M3 Junction 9 Improvement Scheme

7.12.7 Statement of Common Ground with Cycle Winchester (Rev 1)

**7.12.7 STATEMENT OF COMMON GROUND WITH CYCLE
WINCHESTER**

This Statement of Common Ground has been prepared and agreed by (1) National Highways Company Limited and (2) Cycle Winchester

**DRAWING TITLE**  
 FIGURE 2.5 - THE SCHEME: TEMPORARY TRAFFIC DIVERSION ROUTES  
 APFP REGULATIONS 5(2)(a)  
 SHEET 1 OF 12  
 DOCUMENT REFERENCE 6.2

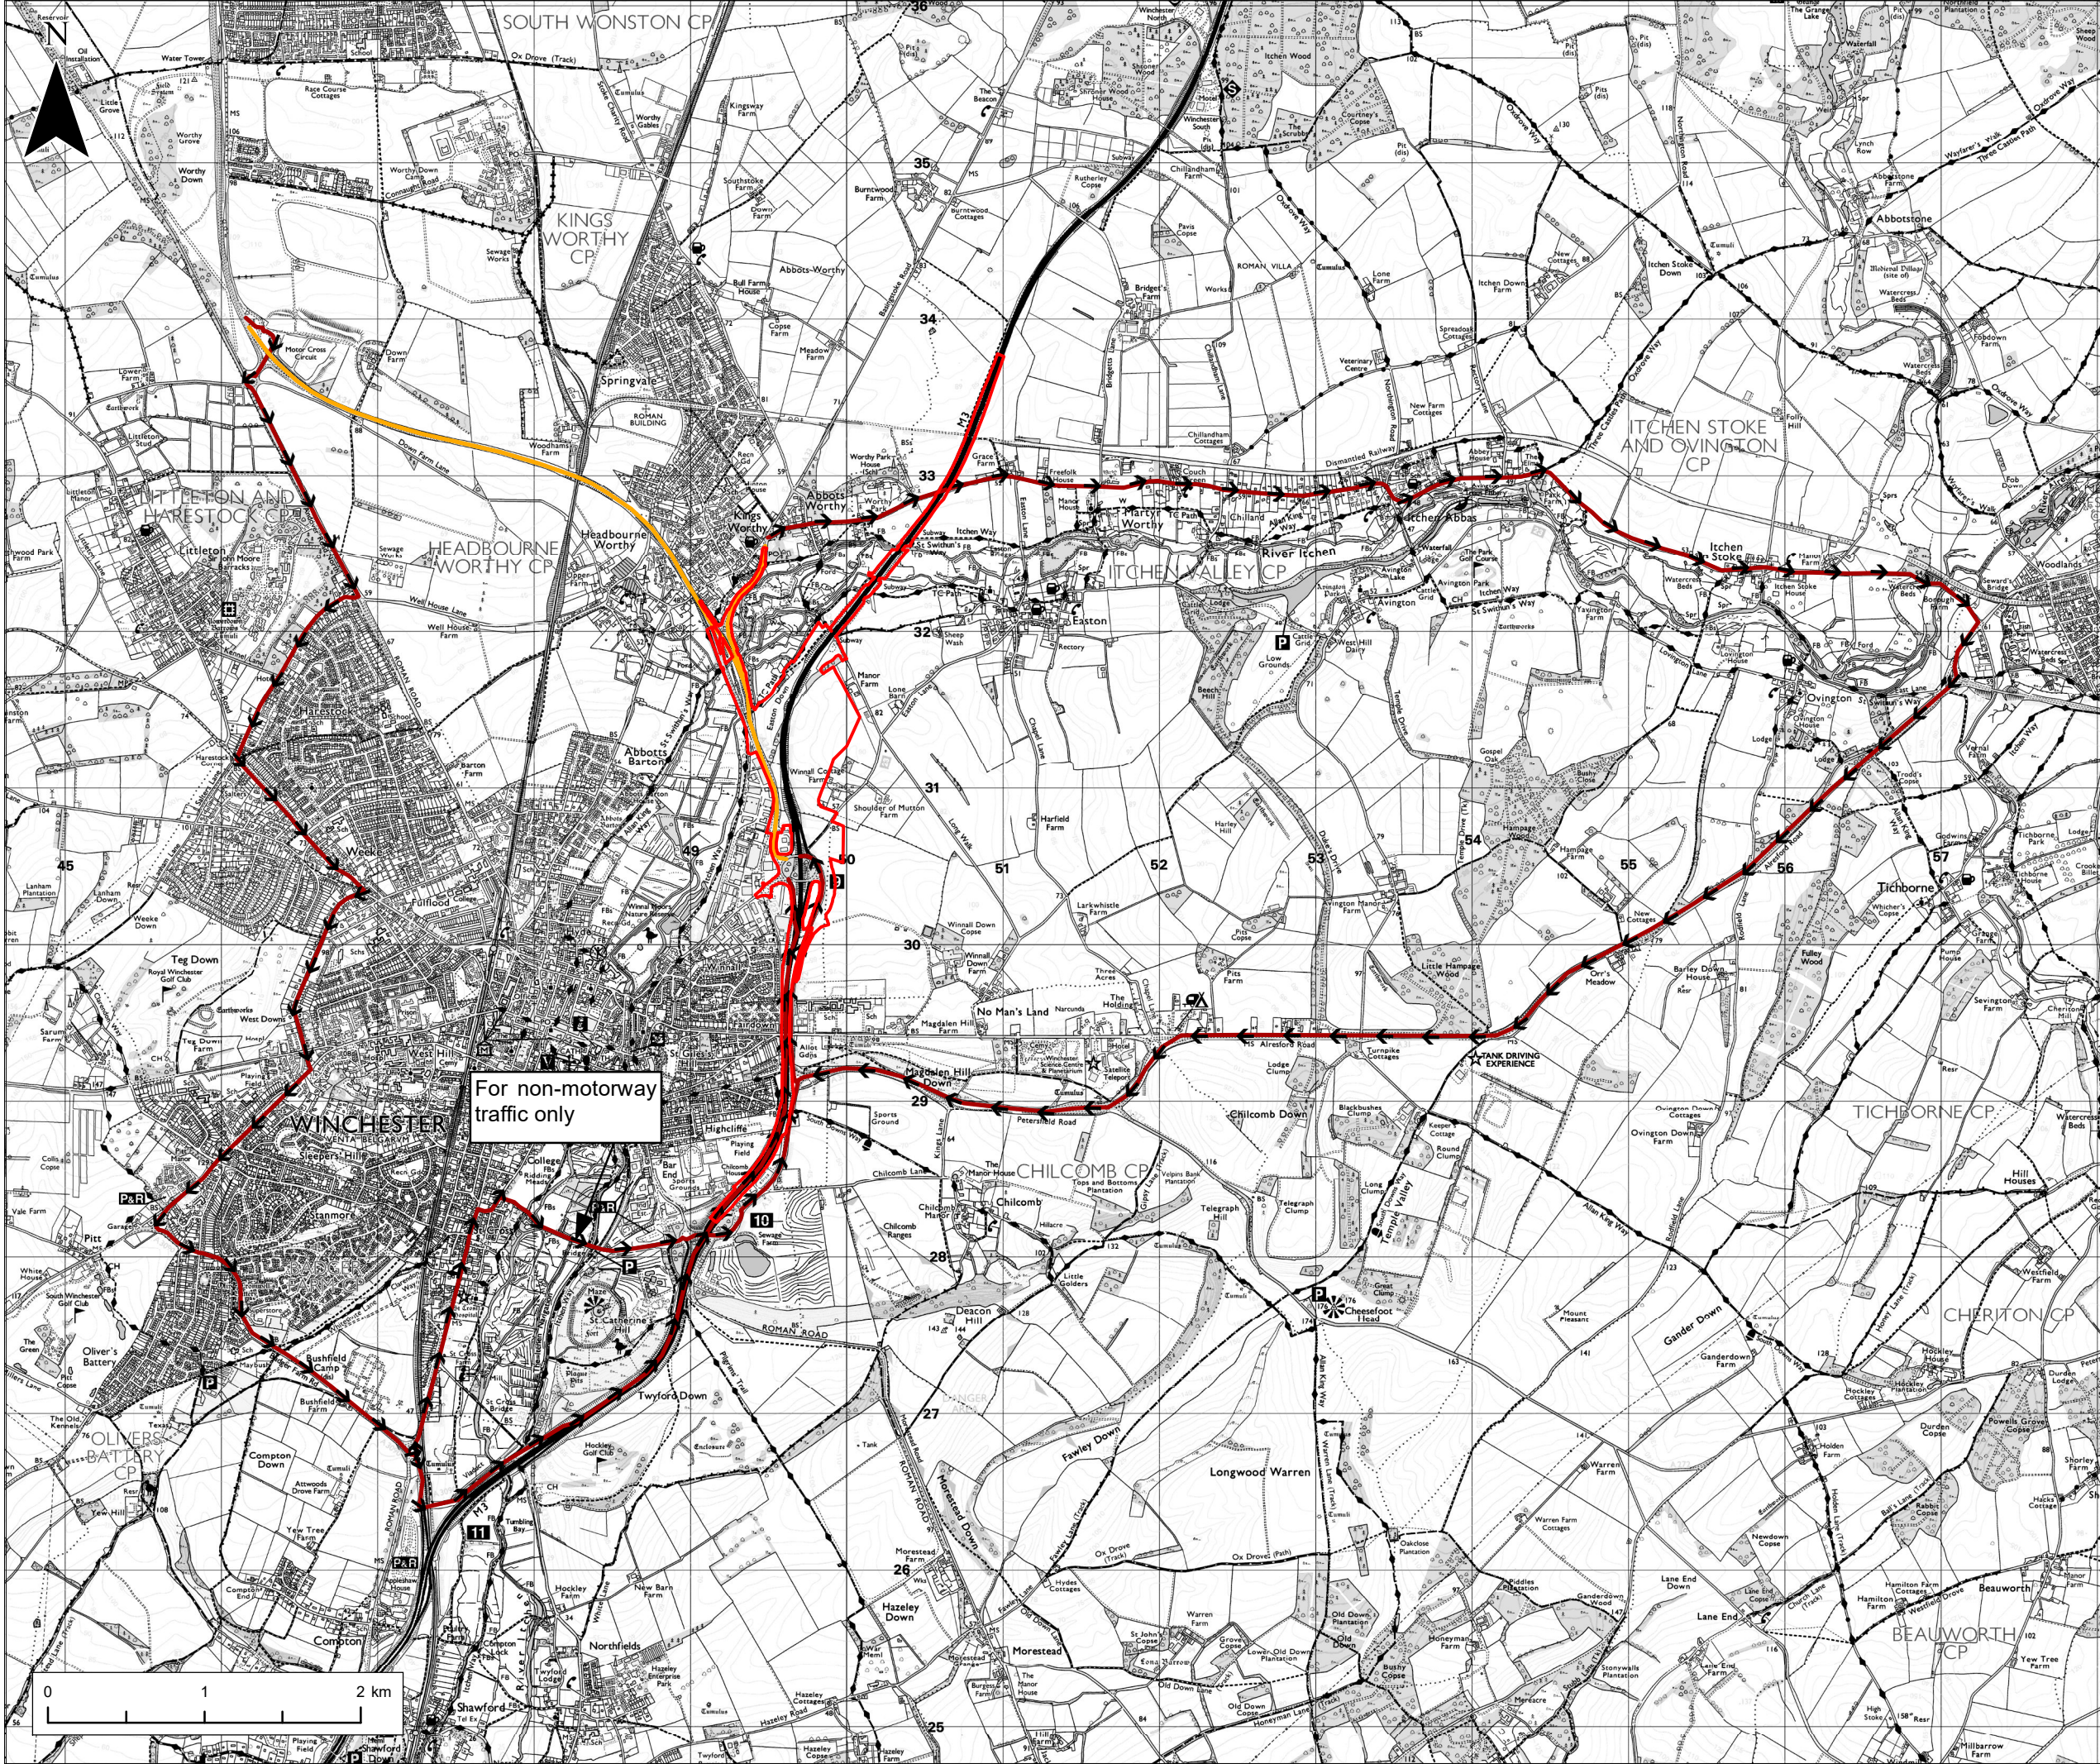
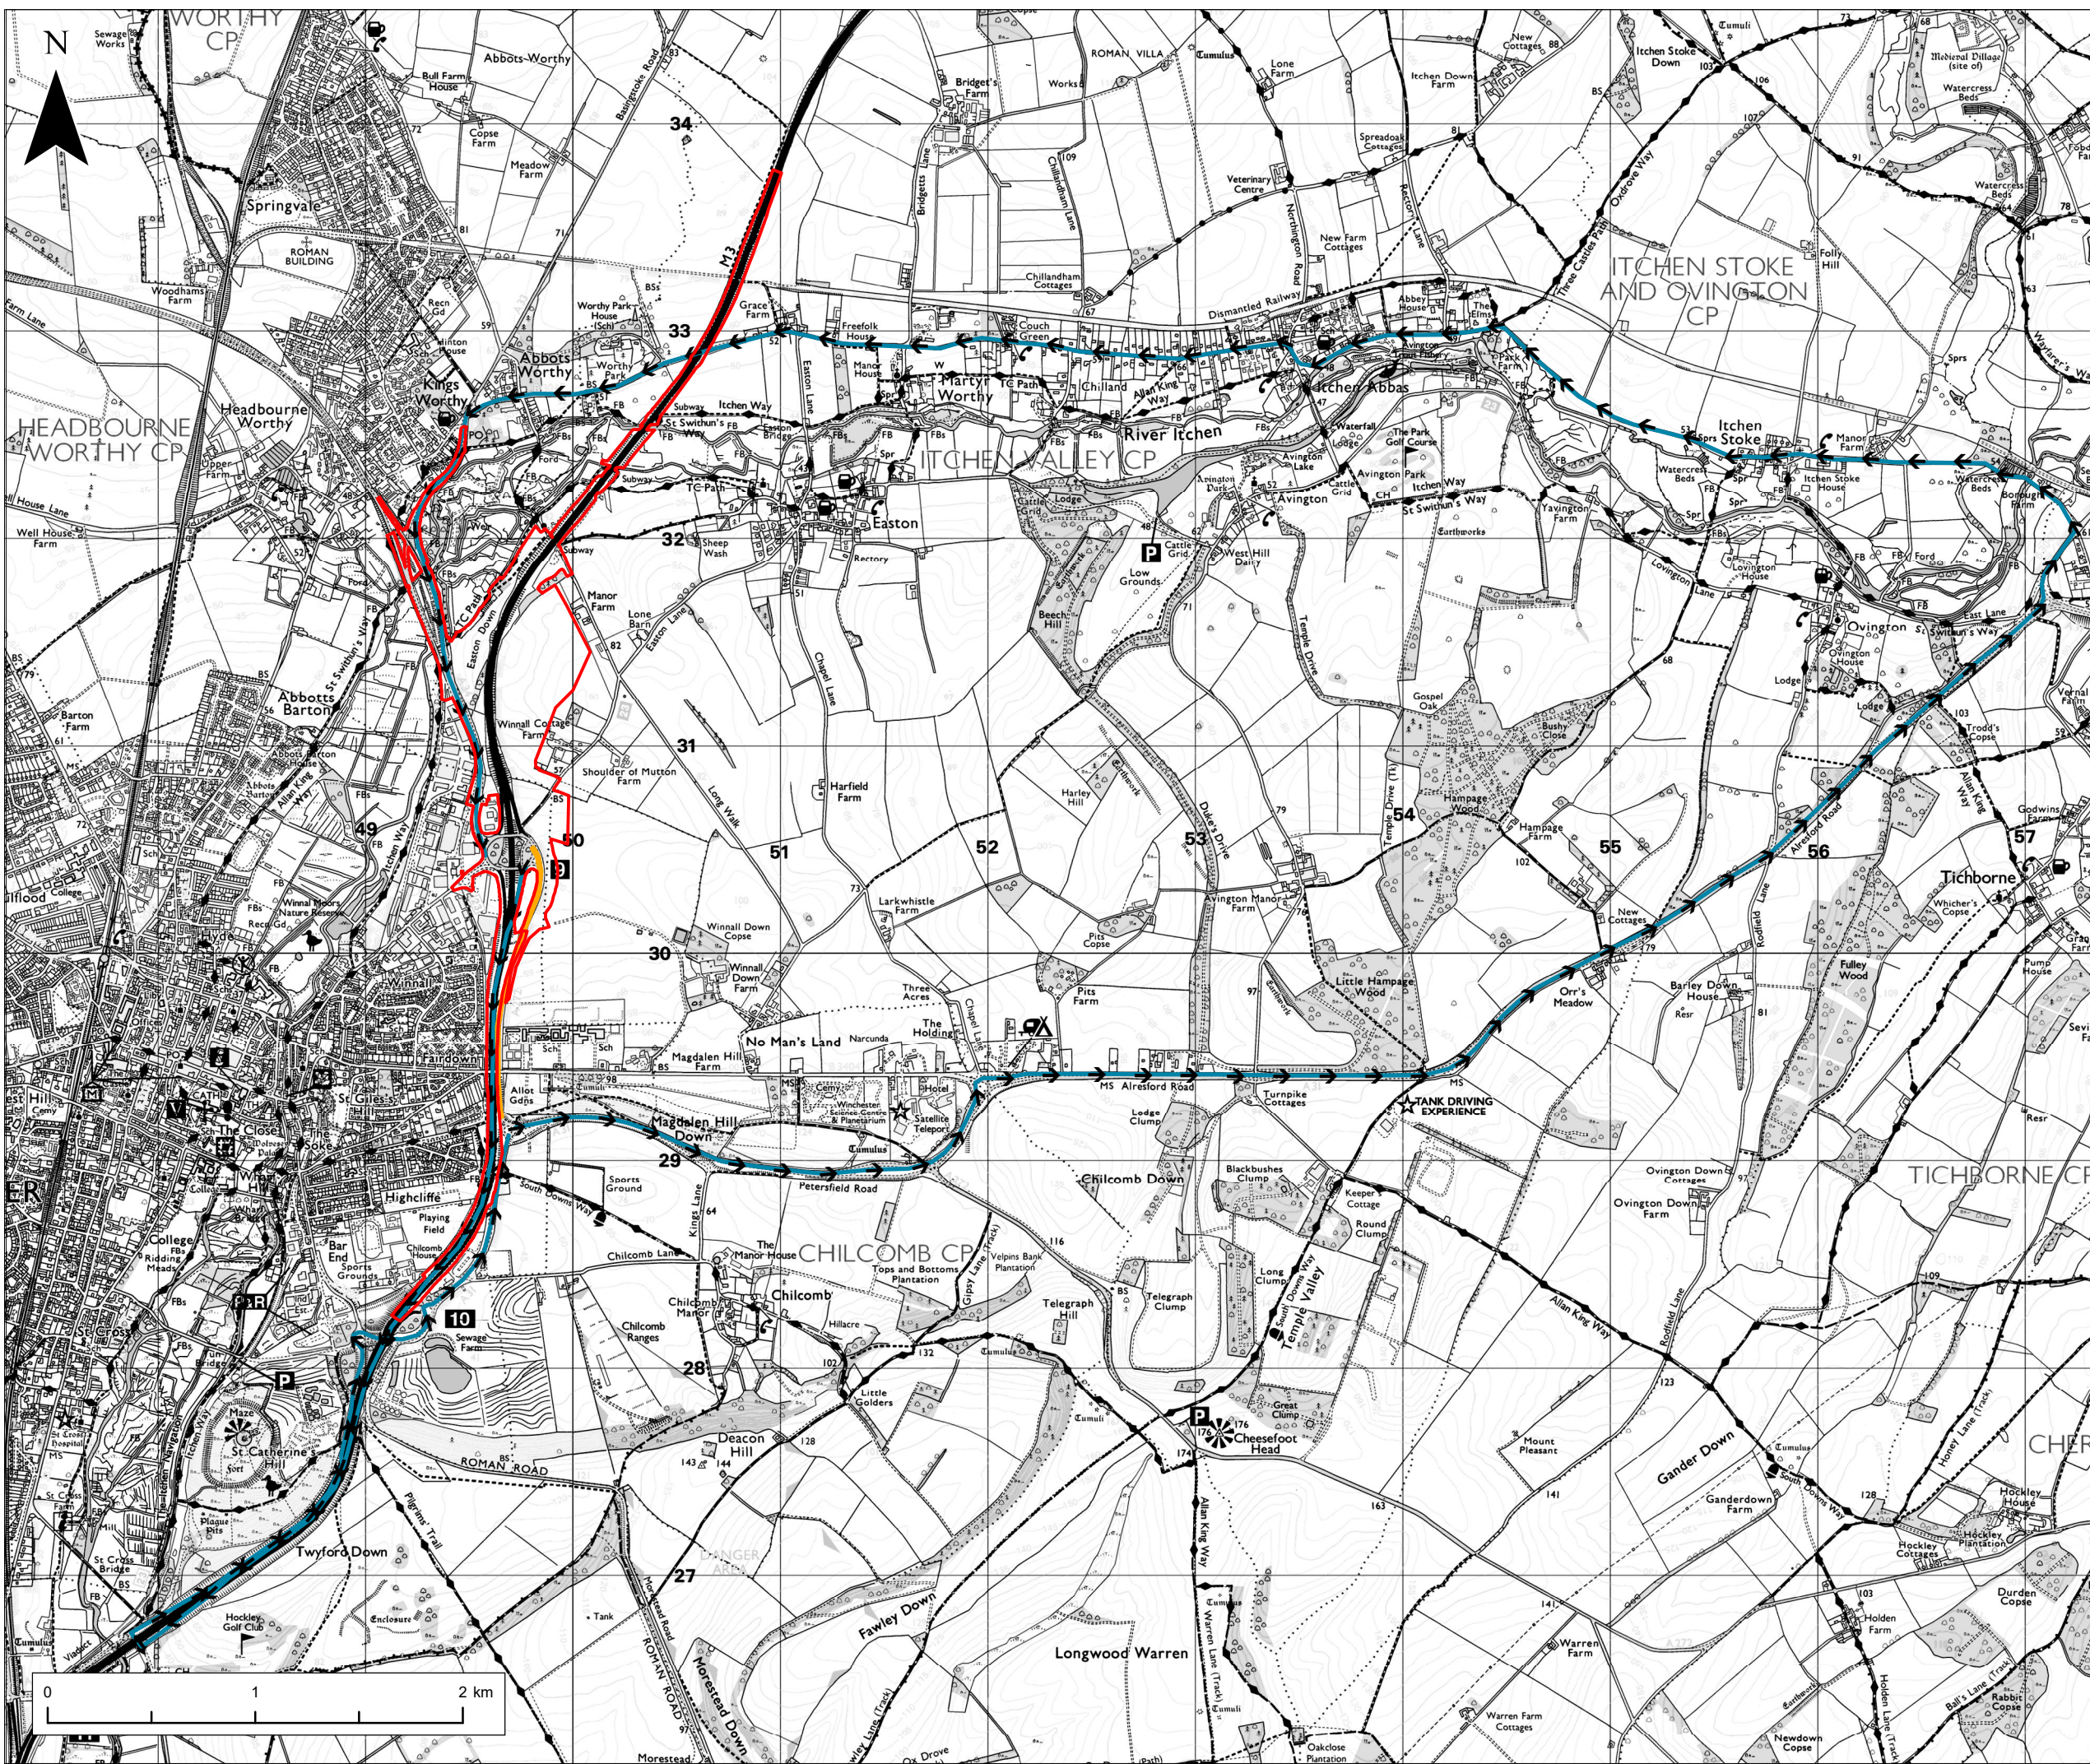
5.2	<p>Diversion routes Impact of traffic diversion on cyclists</p>	<p>Outline Traffic Management Plan (7.8, Rev 1), Figure 2.5 of Chapter 2 (The Scheme and its</p>	<p>Cycle Winchester has the impression that the project team has not yet considered the impact that traffic diversions during construction will have on cyclists. Examples of areas where the diverted traffic might have an impact on cycling</p>	<p>Diversion routes via the B3047, the B3420 Andover Road and road east of the junction (A31) will be implemented at various stages of the Scheme. The works are planned to be undertaken during overnight off-peak closures</p>	<p>Not agreed</p>	<p>8 November 2023</p>

Reference	Issue	Document References (if relevant)	Cycle Winchester's Position	National Highways' Position	Status	Date
		<p>Surroundings – Figures (Part 3 of 4) of the ES (6.2, APP-063)</p>	<p>include many of the major routes in and out of Winchester, as a Junction 9 closure or complete M3 closure would force more traffic onto these roads. Some examples:</p> <ul style="list-style-type: none"> ▪ B3047 Worthy Road/Martyr Worthy Road ▪ B3335 St Cross Rd and Twyford Road ▪ B3420 Andover Road ▪ B3330 Bar End Road ▪ Minor roads, especially in the upper Itchen valley east of the junction <p>In addition, the location of the site offices and parking immediately to the east of the junction suggests that the likely travel-to-work route of staff working on the project would clash with the proposed cycling diversion routes as well as impacting walkers, cyclists and horse riders on the section of NCN23 near Easton village. (See 6.2 Environmental Statement Chapter 2 The Scheme and its Surroundings - Figures Part 1 of 4).</p> <p>Again, we would like to see a clear consultation process that will ensure that consultation happens, that the effects on non-motorised road users are accounted for, and appropriate measures are taken.</p>	<p>(when there is less traffic on the network) and several extended weekend closures.</p> <p>The B3335 St Cross and Twyford Road and B3330 Bar End Road have been referenced as secondary diversion routes and should only be used by non-motorway traffic, or for those accessing the residential area at Bar-End.</p> <p>There are mitigation measures for rat-running and this will be monitored throughout construction of the Scheme.</p> <p>National Highways commit to producing a PRoW Management Plan during detailed design. National Highways will have regard to Cycle Winchester's views during the development of the PRoW Management Plan during detailed design. This will include controls to manage the crossing of the haulage route and NCN Route 23 and on Long Walk.</p>
